May 30, 2024

RE: Responses to Site Development Comments
Dutch Bros Coffee (CO0907)
5810 Omaha Boulevard, Colorado Springs, Colorado
City File No. PPR2413 / Our Job No. 23098

The following outline provides each of your comments in italics exactly as written, along with a narrative response describing how each comment was addressed:

Job Number: 23098
Sheet: 3
2019 DB
Franchising USA, LLC

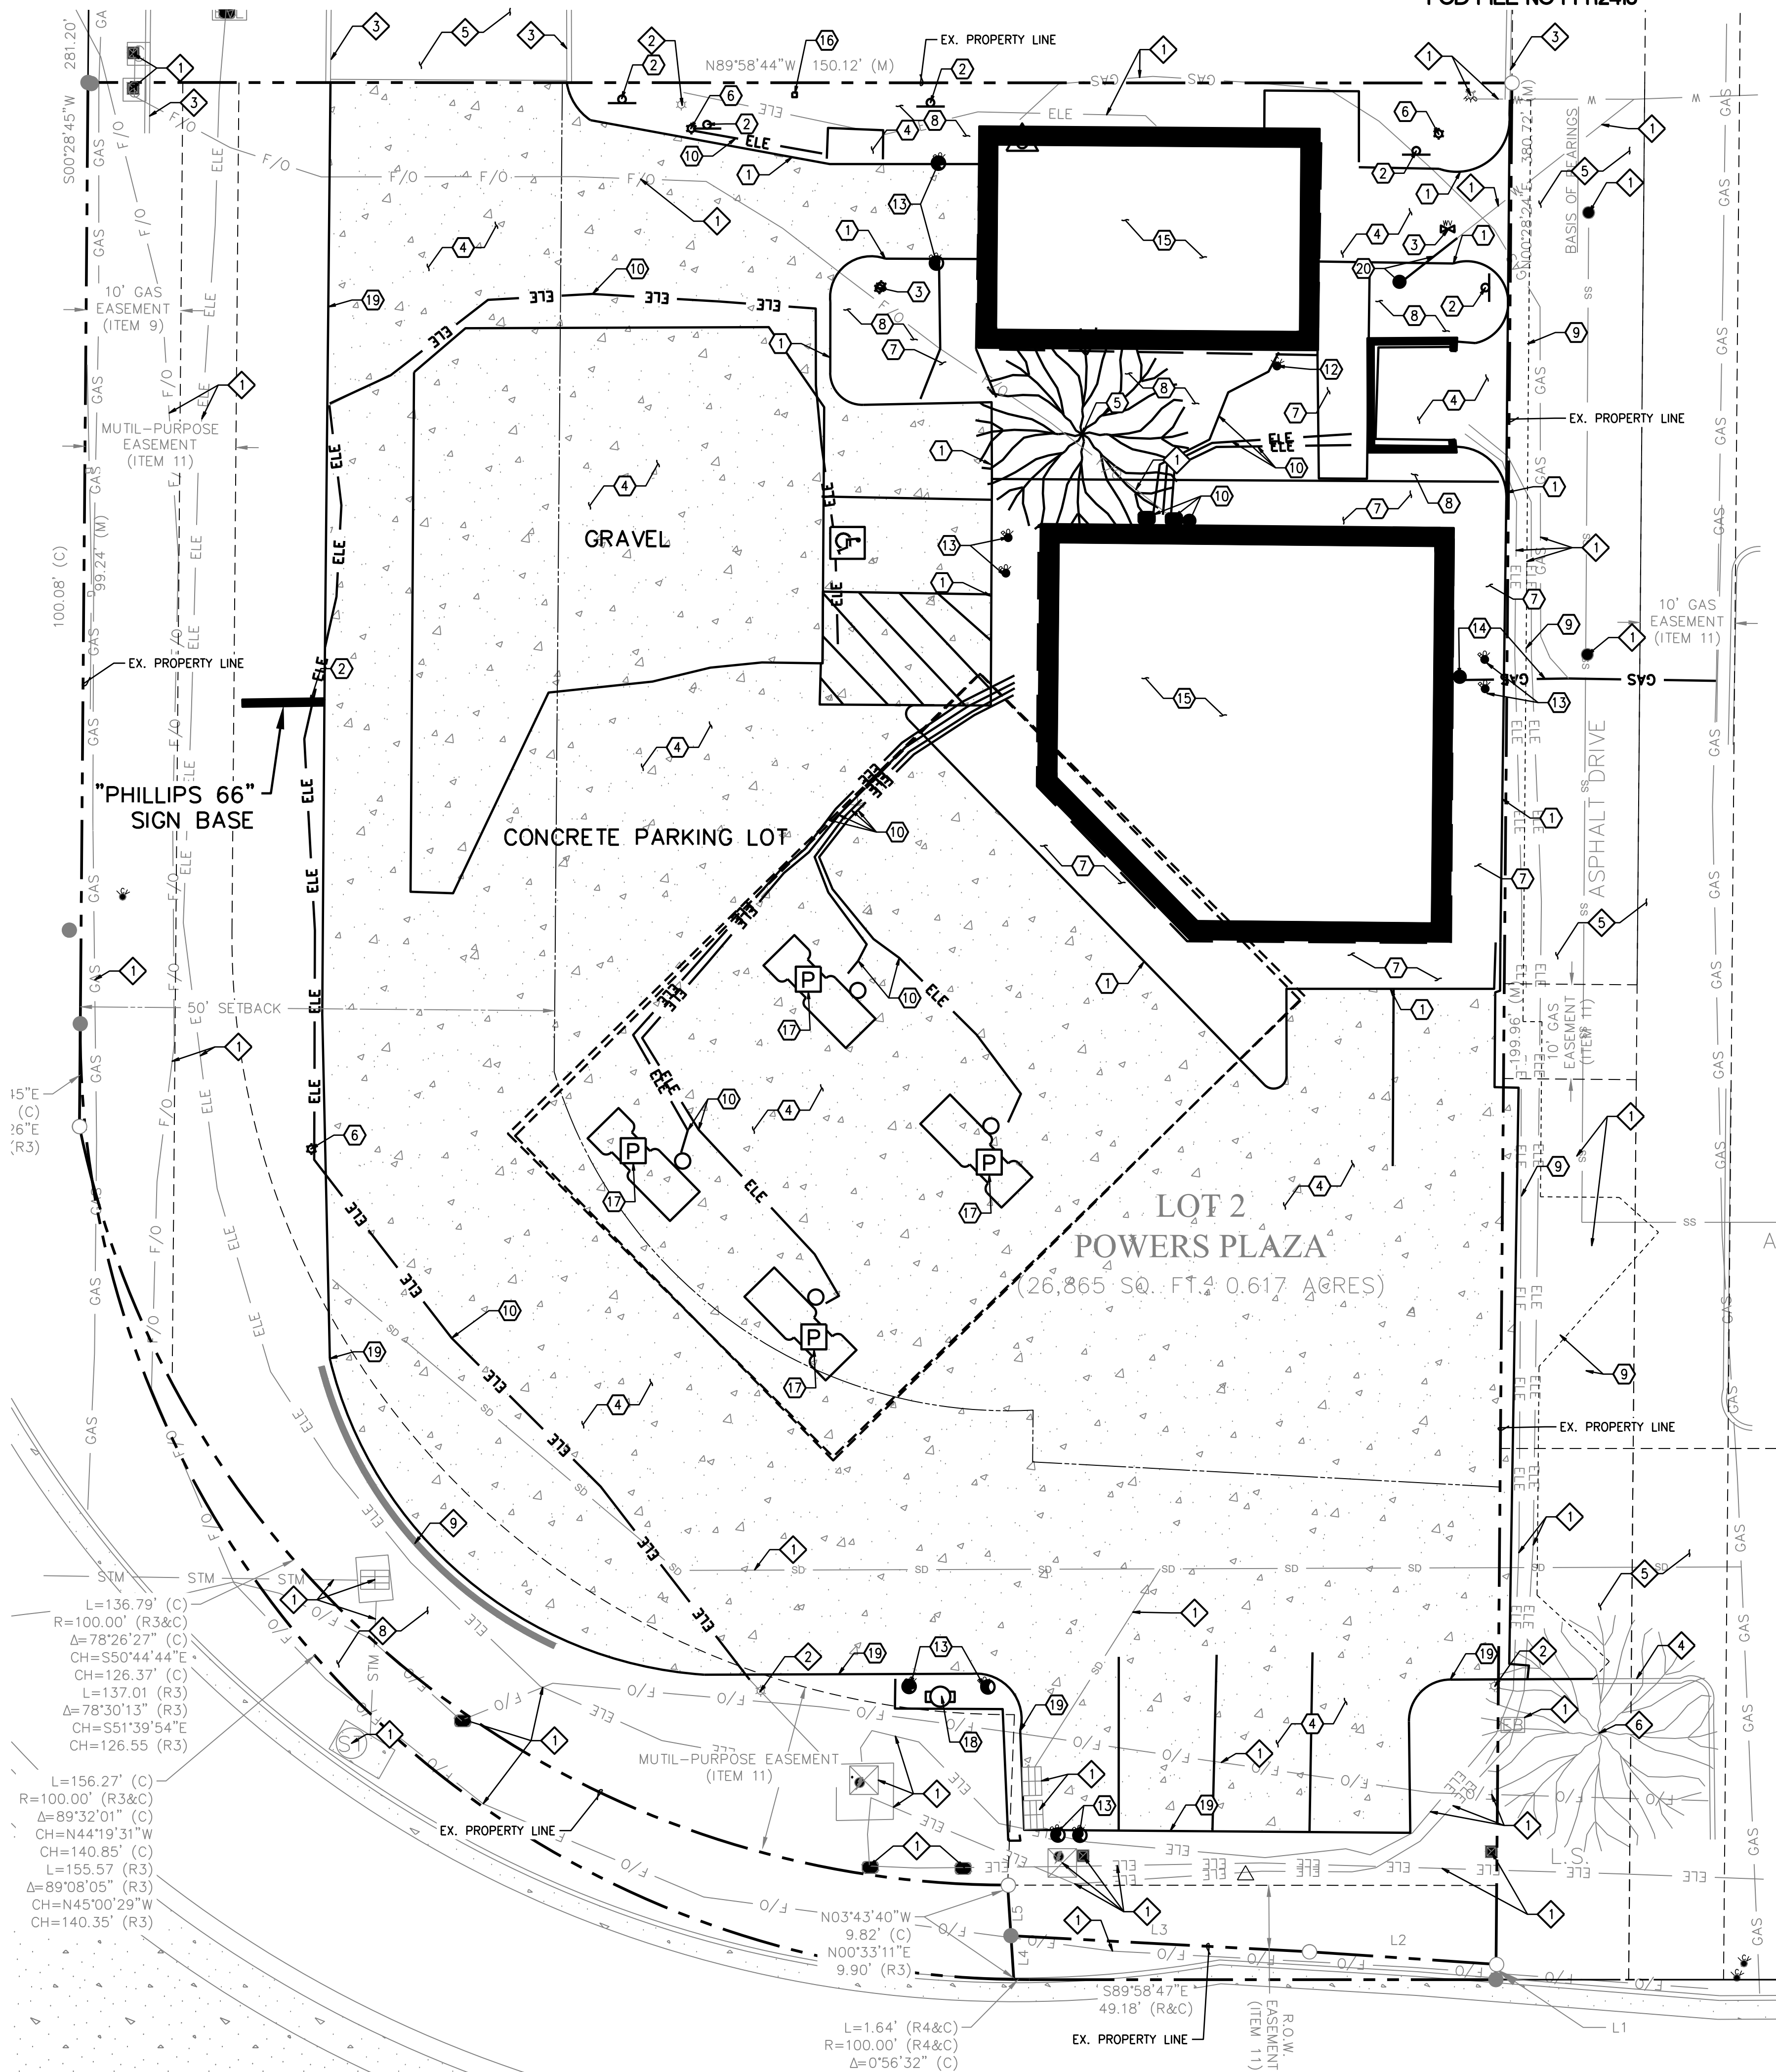
- *Restart list at 1*

Response: The ALTA Survey is provided as reference only. The numbers cannot be relisted as they correlate to the exception numbers in the Title Report.

Job Number
23098
Sheet
4
2019 DB
FRANCHISING USA, LLC

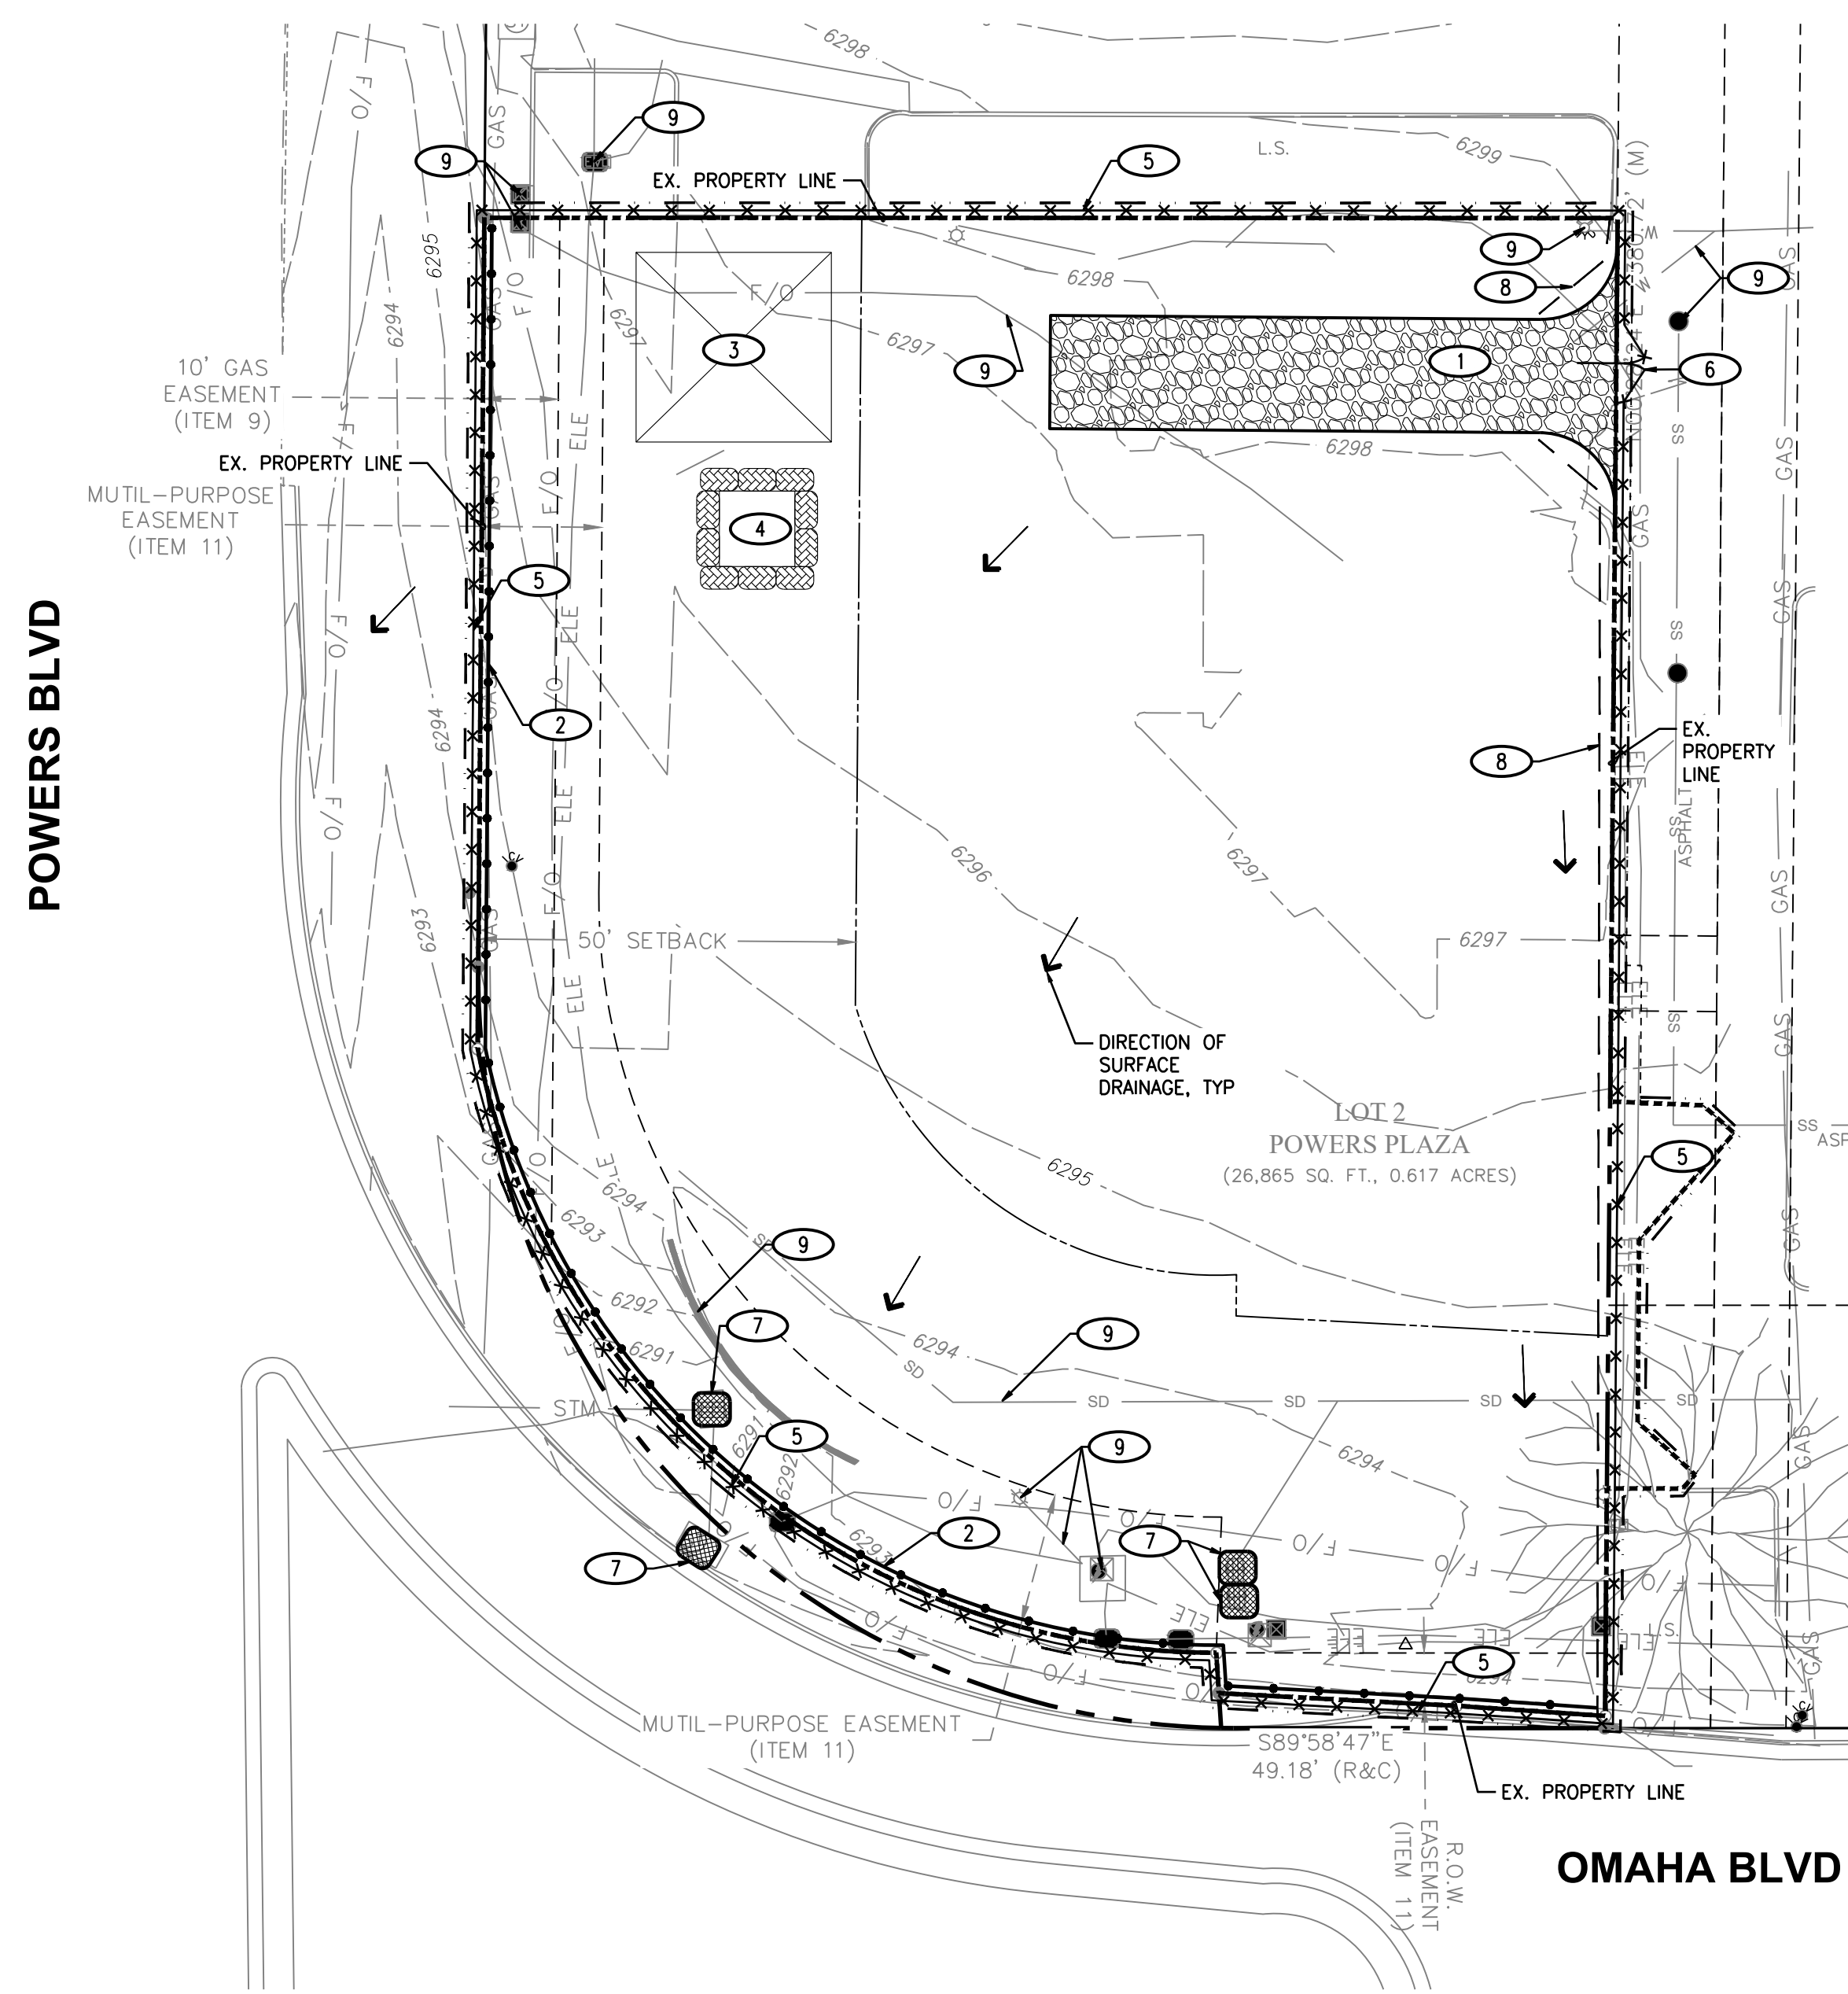
- *Why is this included? Will some of the site be blanketed? I don't see this in plan view.*

Response: The Erosion Control Plan has been updated. There is no erosion control blanket.
